APPENDIX K – Stakeholder Submissions and Briefing Minutes

The Scottish Hospital Redevelopment - in response to the Open Day & Workshops

Scottish Hospital Development

### 196 Glenmore Road Balcony RL 43.6 Existing

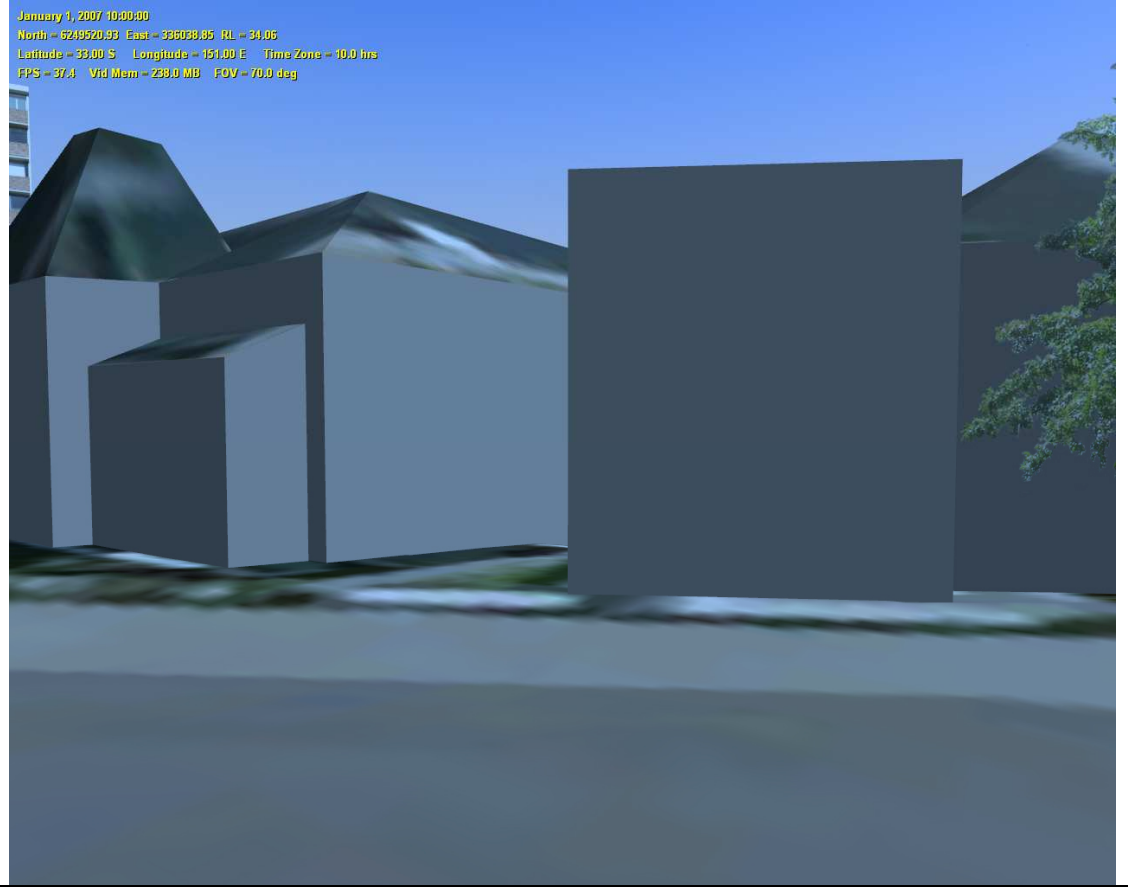
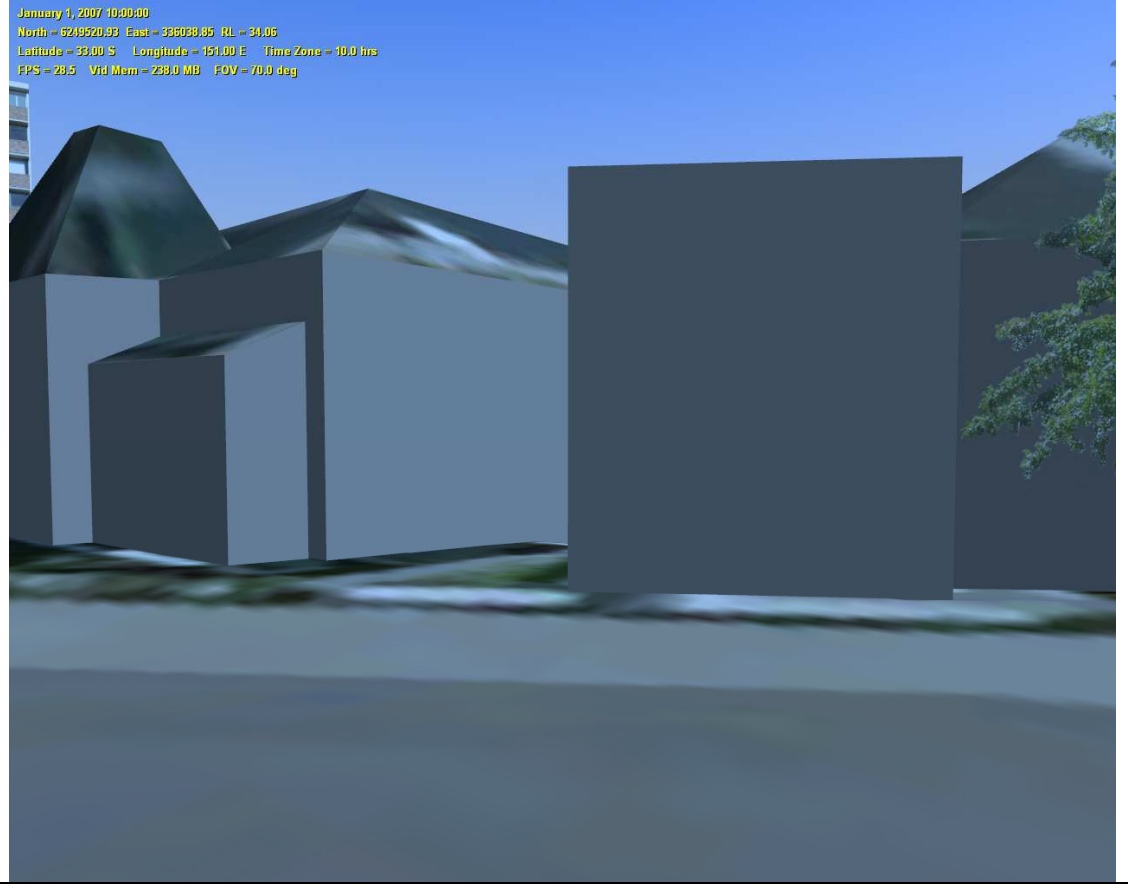
- Six floors above Brown Street on the view axis of Glenview Street
- Building on the ravine, a micro rainforest environment, to connect to Brown Street

Residents are particularly concerned that the development on Brown Street will block views from Glenview Street.

Although we are generally looking at one building being up to nine stories high, this building will be nestled in the on-site gully within the tree canopy. The proposed above-street levels will not be dramatically different or striking when compared to the existing nearby buildings.
